From: Anita Gardner
Sent: 06 October 2017 09:01
To: Planning.Responses
Subject: FW: Planning Application at Existing Telecommunications Installation Ferring Water Pumping Station - Replacement monopole & antennas & 1 No. replacement cabinet (Ref: FG/139/17/PL)

From: Alan Neale [REDACTED]
Sent: 05 October 2017 18:45
To: Anita Gardner
Subject: RE: Planning Application at Existing Telecommunications Installation Ferring Water Pumping Station - Replacement monopole & antennas & 1 No. replacement cabinet (Ref: FG/139/17/PL)

Photomontage Portfolio

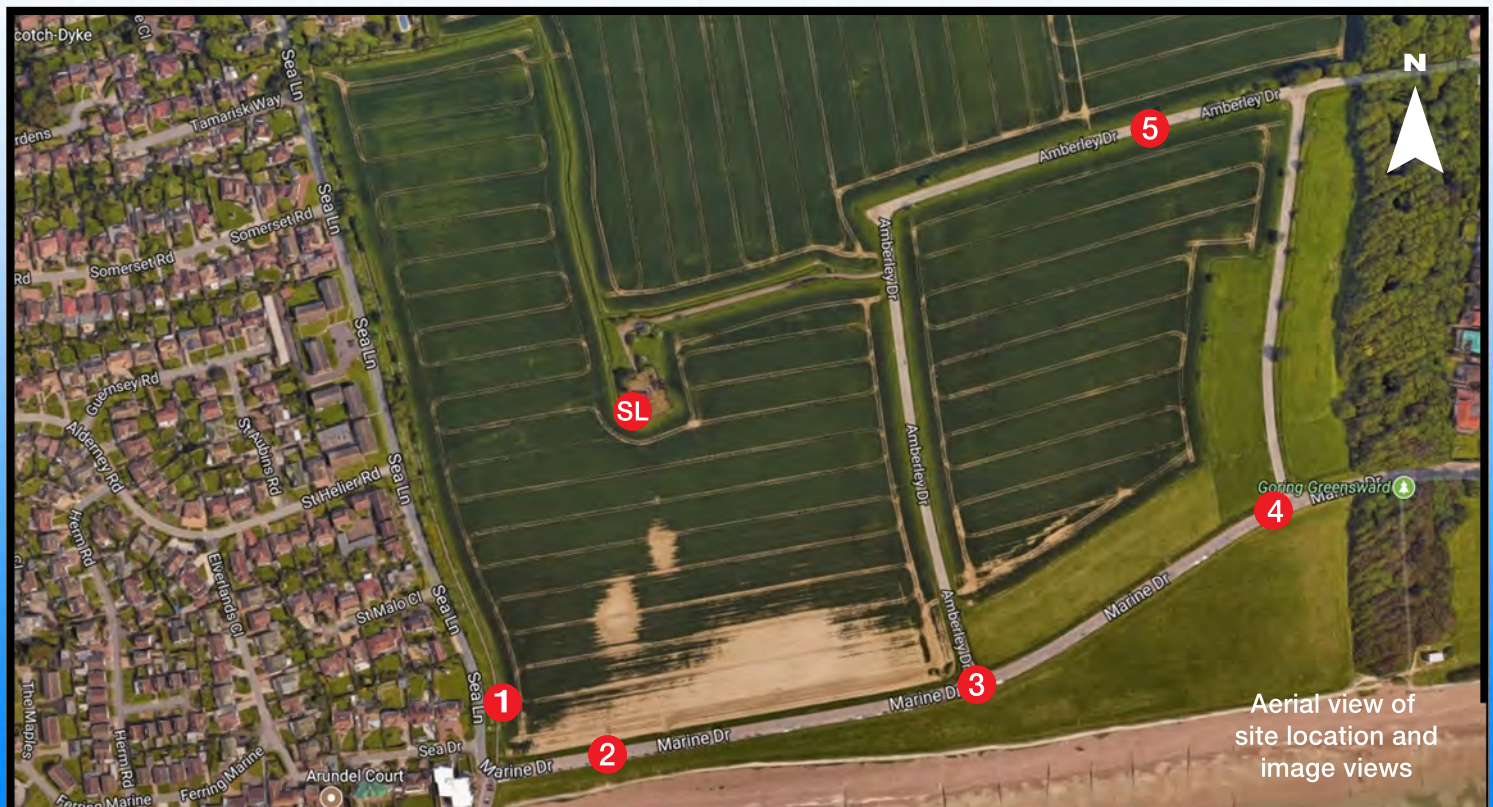
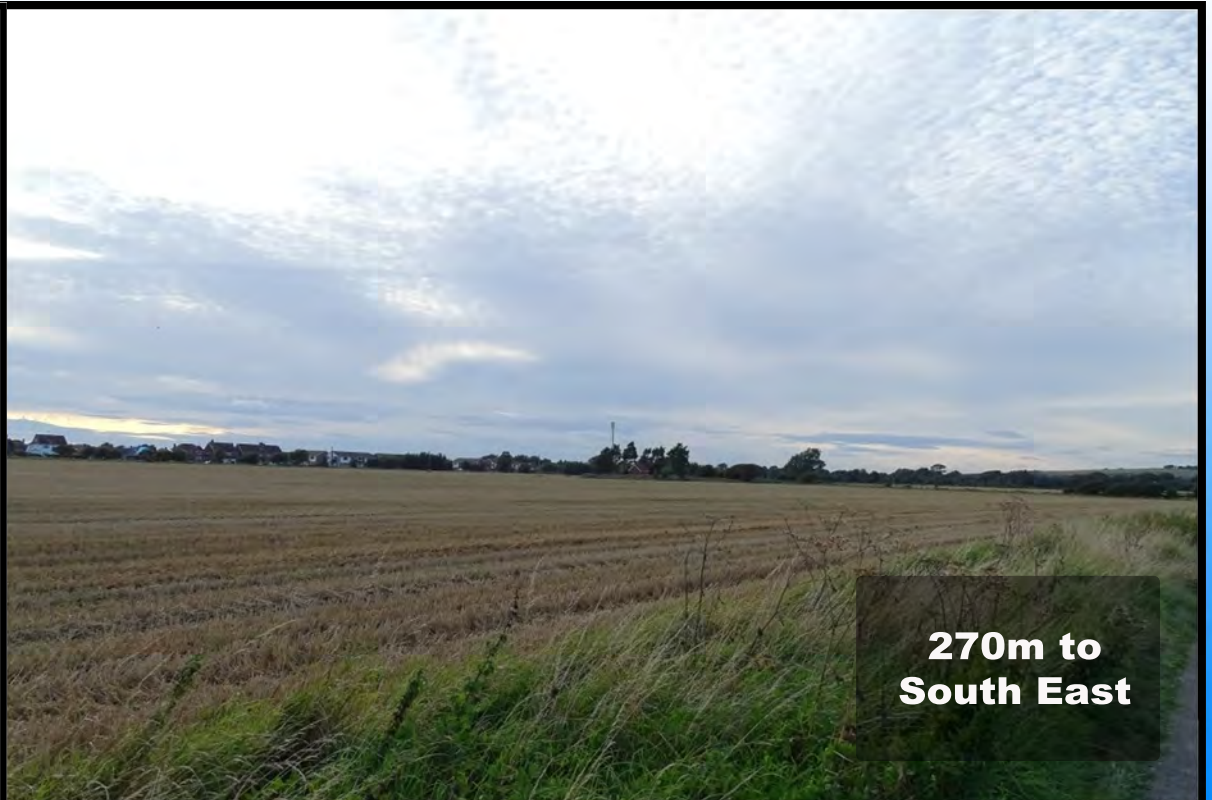
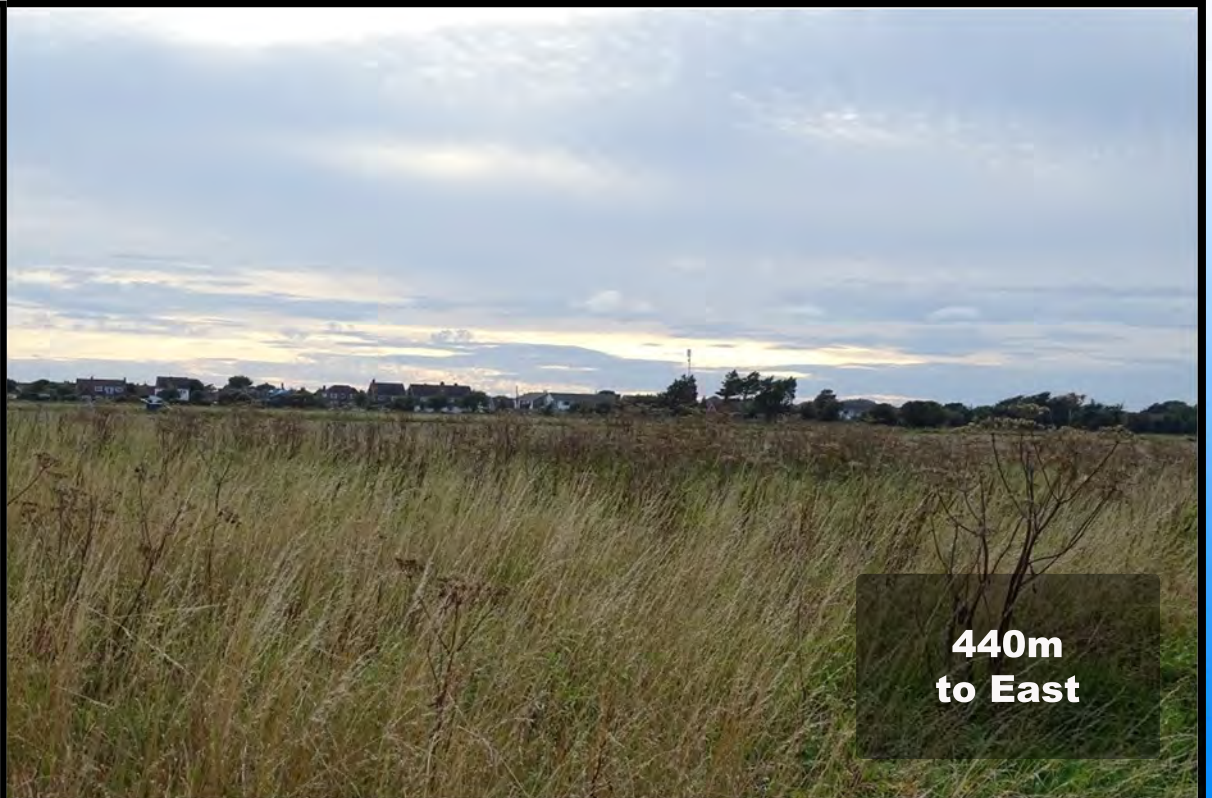
I think that the Parish Council are saying that if the trees were pruned and reduced in height then, in turn, the proposed mast could also be reduced in height, whilst maintaining the level of coverage, capacity and connectivity it is hoped to achieve as a result of the current proposal. A lower tree line and consequently a lower mast would have less visual impact.

Is the current height of the trees a contributory factor in the need to increase the height of the mast?

I would again refer you to the photomontages, which are taken from a variety of genuine public viewpoints. These demonstrate that the site is remote in terms of all local views, and that the impact of what is just a 3m increase in relation to those views is pretty minor. Please also bear in mind that we have repositioned the new pole as you required, and this has provided a little more screening when viewed from the south.

I do not think there is anything more that we can do in this case, and I do feel that although the drawings might indicate that the changes will have an impact on the local area, these are necessarily bald, 2 dimensional representations. In fact, as demonstrated by the photomontages, the reality of the impact when viewed locally is not significant.
